**ADC Planning Consultation
Response from the Historic Buildings Adviser**

Application Number	R/135/12/L
Address	Old Barn Cottage, 49 Sea Lane, Rustington
Description	New pedestrian access in Cudlow Avenue
Case Officer	Anita Gardner
Site Visit	31 August

NORTH ELEVATION

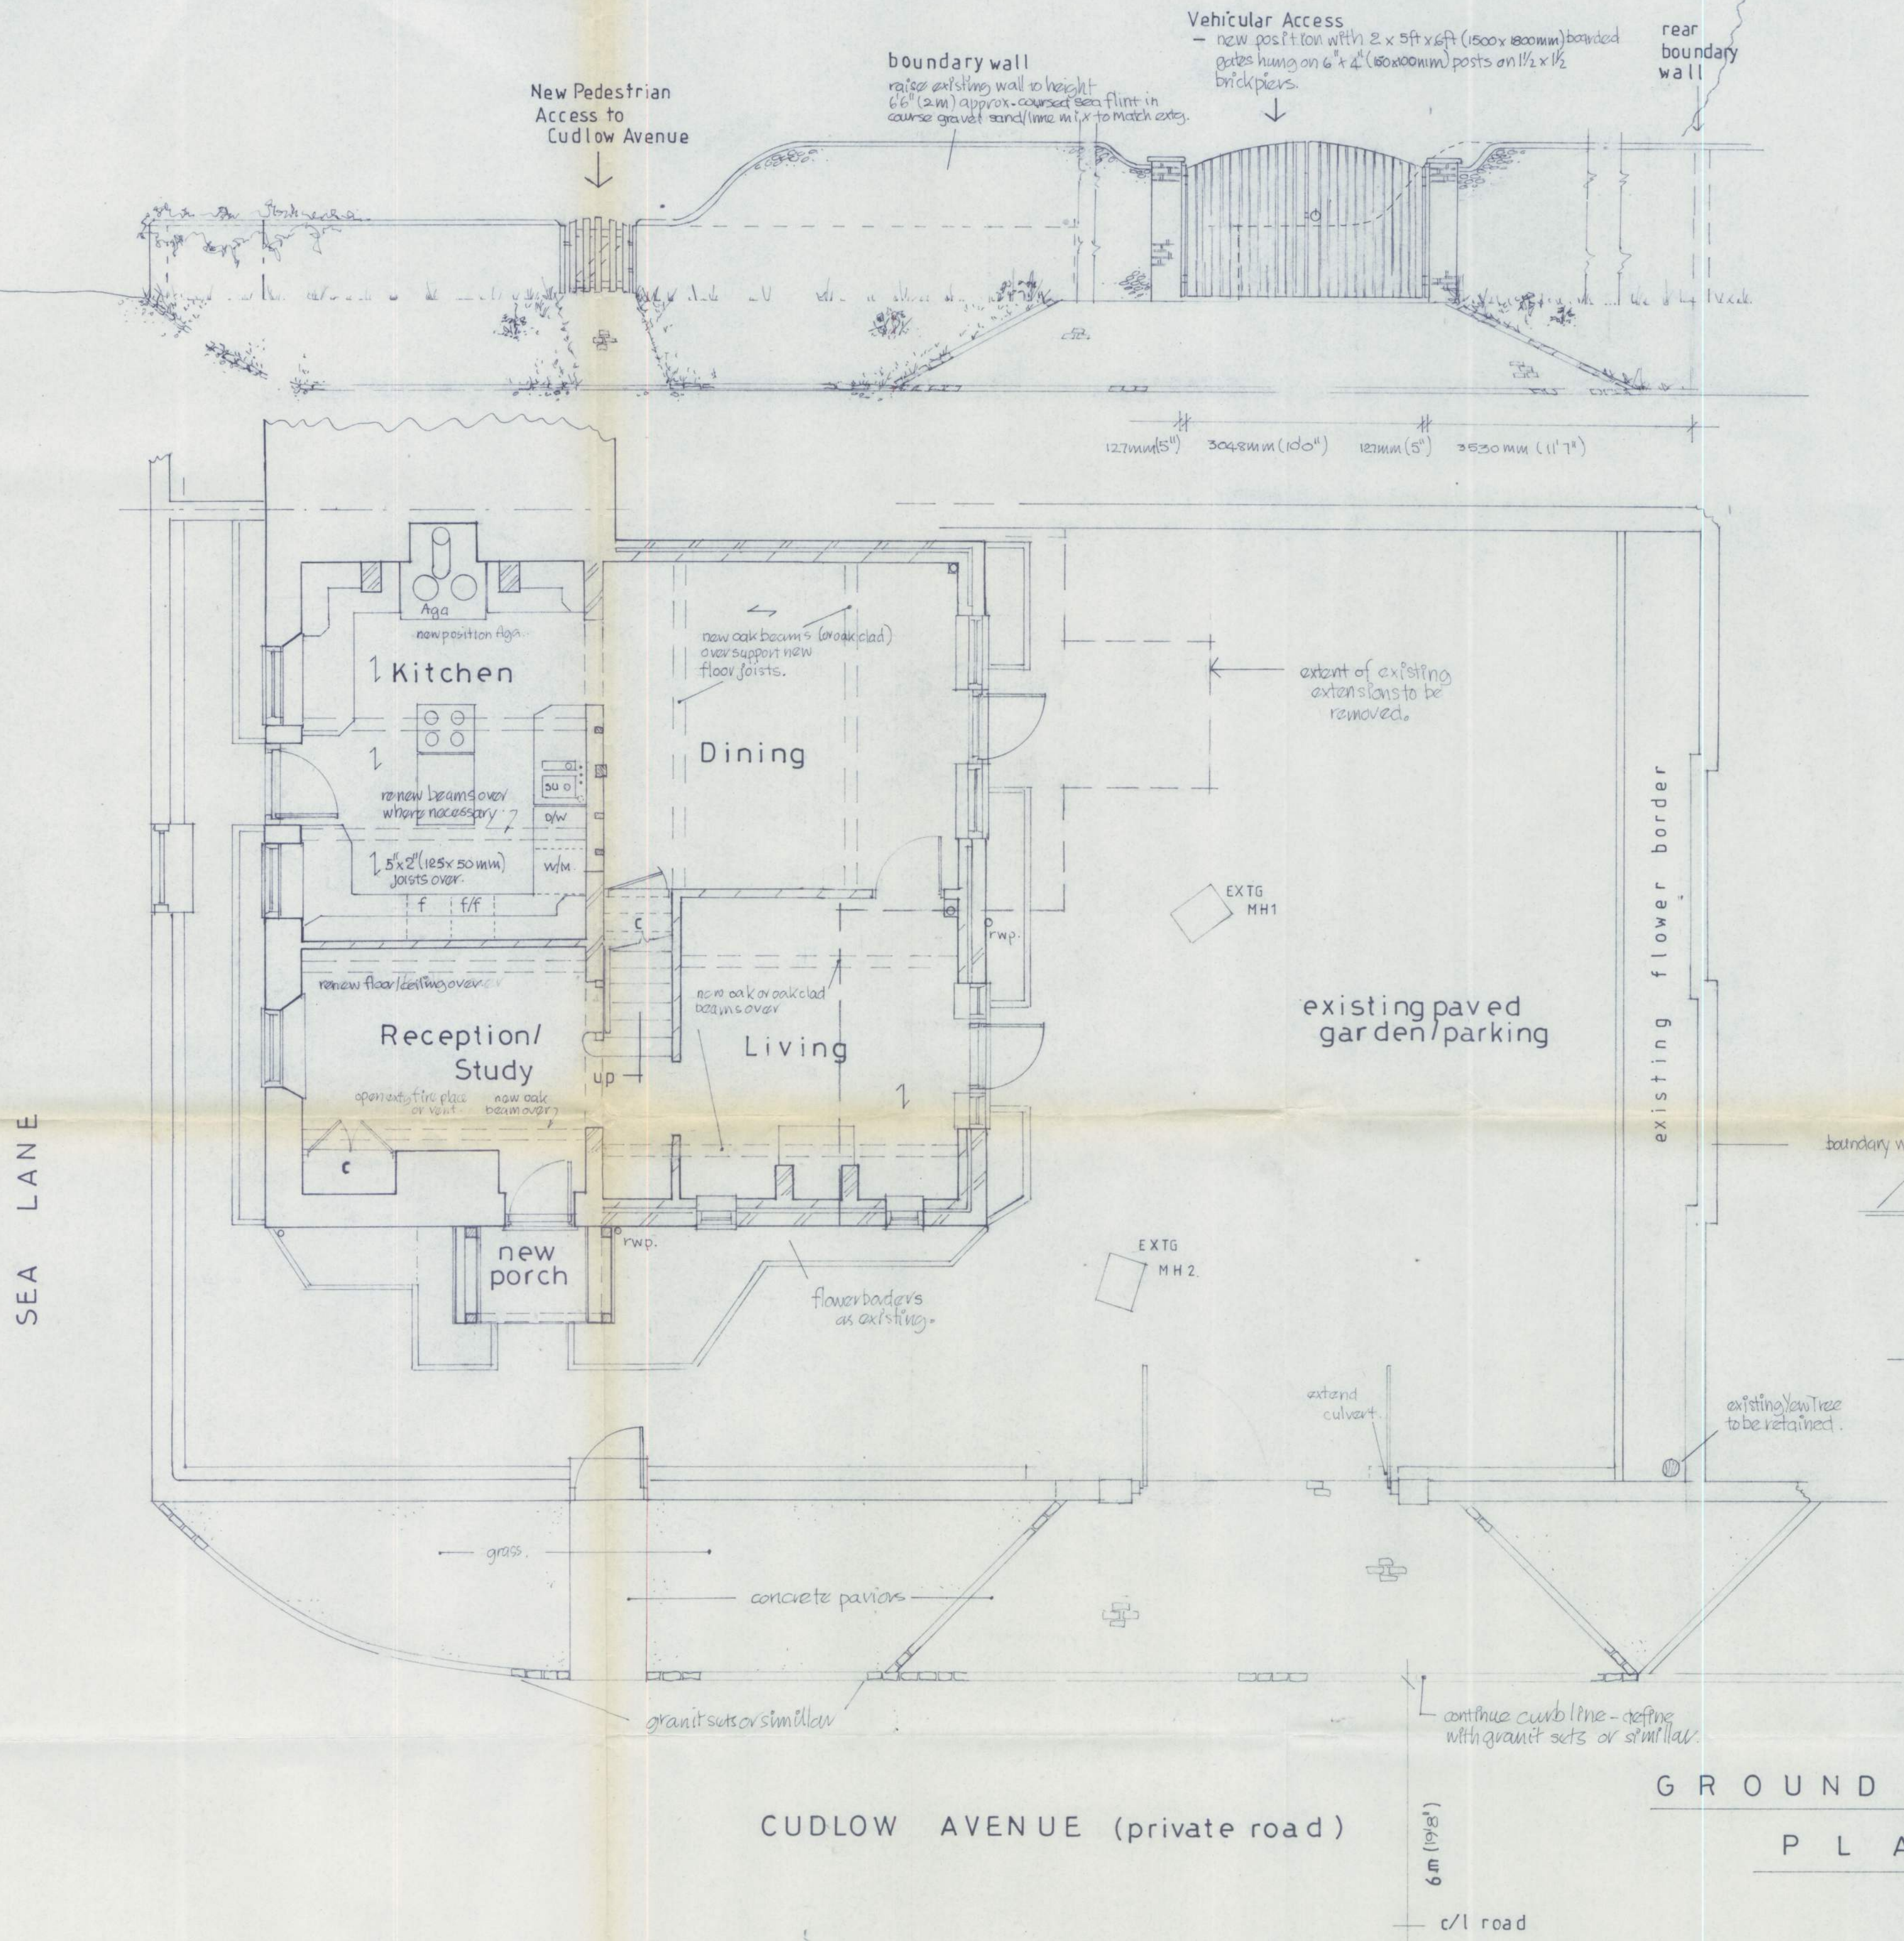
Please condition details of gate design and finish. This should be an exposed hardwood (oak) or a painted timber. A stain finish should ideally be avoided.
